Your Ref: OWPC26181
Our Ref: LU/48/20/PL 19-02-2020
Please ask for:
Mrs A Gardner

Demolition of 1 No. bungalow & outbuildings & erection of 22 No. dwellings with associated parking & open space. This application is a Departure from the Development Plan.

Southdown Nursery Old Mead Road Littlehampton

Thank you for your internet representation made on 25th March 2020 which has been recorded as '**an objection**' with the comments as follows:

Plans & Elevations

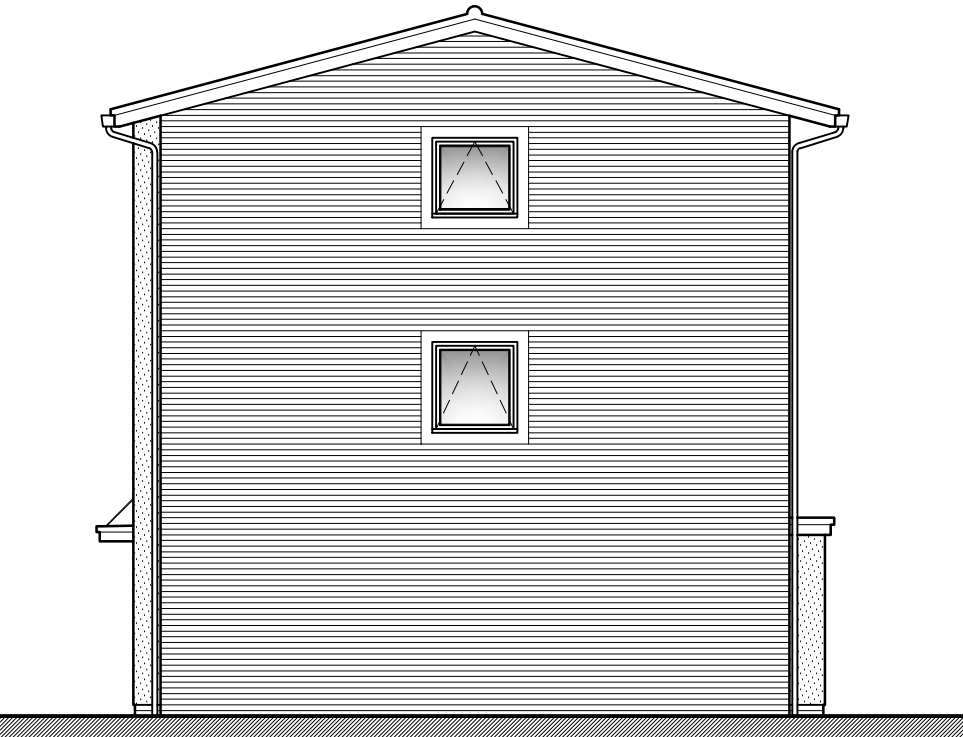
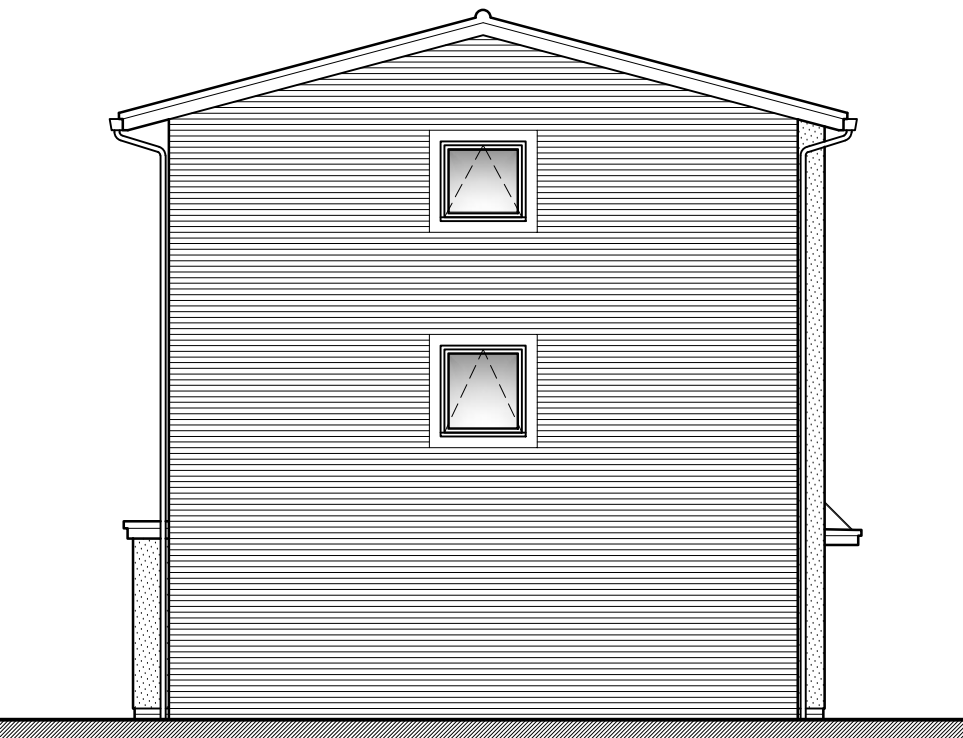
4 The designs of these houses/flats are completely out of character with the area and would be an eye sore. Furthermore, as these would be 3 storeys tall buildings, this would overshadow Glenvilla by restricting light (an objection to the previous application).

DRAWING TITLE
Proposed Site Layout Plan

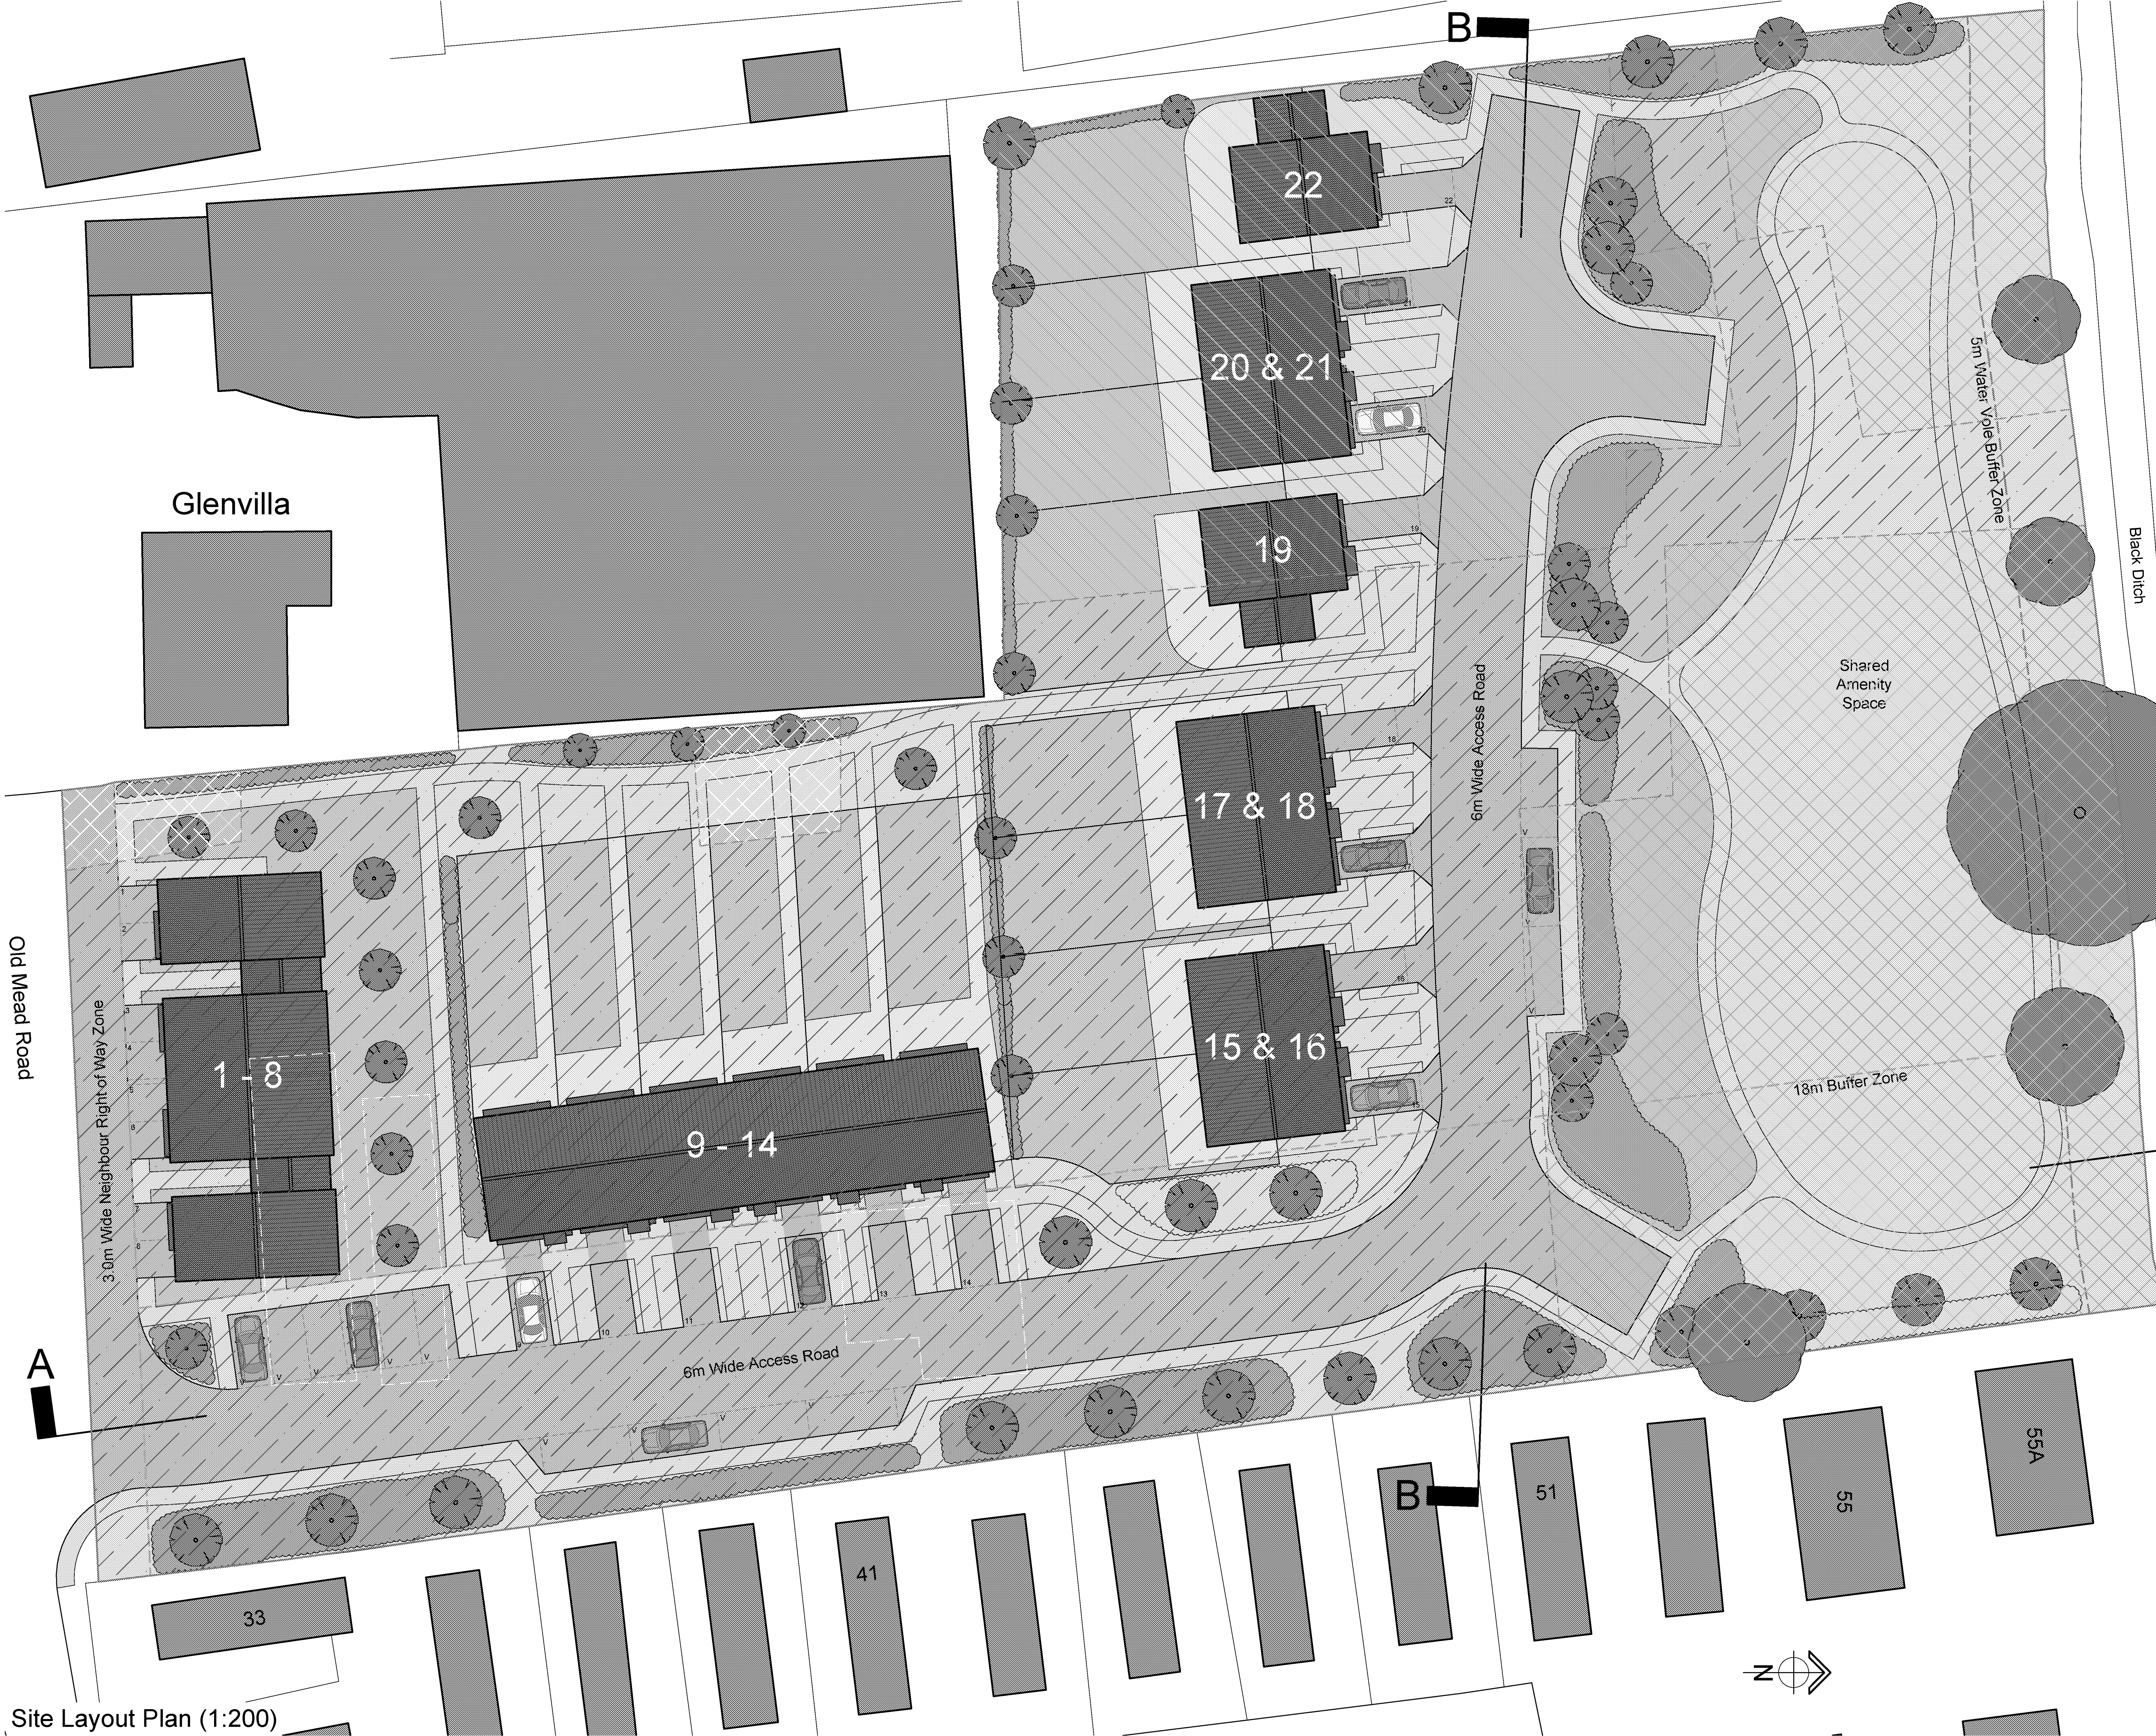
5 One of our greatest concerns is that these plans do not accurately portray the land so cannot be taken as a true representation. Firstly, there is no mention of the existing borehole that supplies water to Glenvilla Nursery, there is no mention of this in the application. The borehole and existing electricity pole are part of the 1971 Conveyance. This states Glenvilla Nursery has the right to use of the borehole to supply water to the property. According to these plans, Properties 1-8 would be situated over this borehole and the pipes through to Glenvilla and no mention of what action would be taken to ensure Glenvilla still has full access to both is made.

6 Further to the above point, Old Mead Road finishes at the entrance of Southdown Nursery and does not continue along our Right of Way as shown on these plans. Also this is only a 10ft strip of land and anyone parking on it will be in breach of the ROW

agreement, no legal parking is allowed on this, this is a great concern as it will block our access into and out of our property.
